Date: 30 April 2024
Our Ref: 24/00299/LBC
Please ask for: Mrs Hannah Roper

Invalid Application Follow Up

Proposal: application for listed building consent for the replacement of the front facade single glazed casement windows with traditional double hung sliding sash windows incorporating 12mm heritage double glazed units
Location: Carwood House Carwood Lane Whittle-le-woods Chorley PR6 7LW
Reference: 24/00299/LBC

# Location Plan

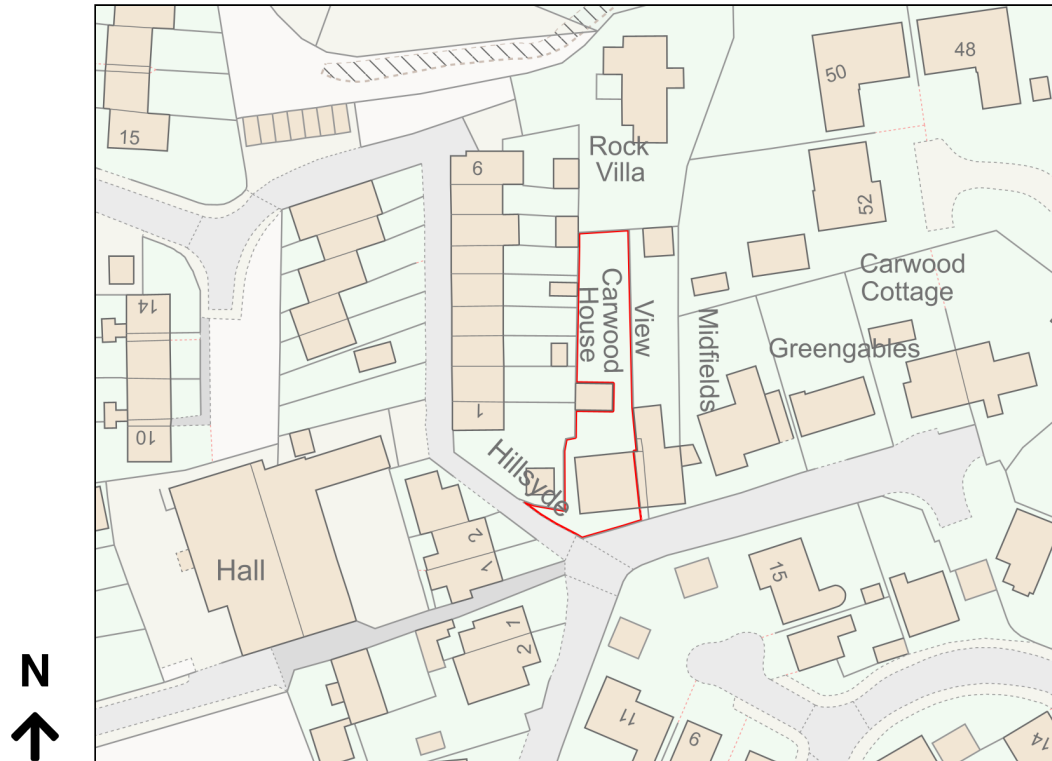
I refer to the above planning application. I note that additional information has been submitted, however the location plan submitted still requires two road names to be clearly annotated.

Please provide a plan with two annotated road names (to a recognised scale and in PDF format) by the 7th May 2024.
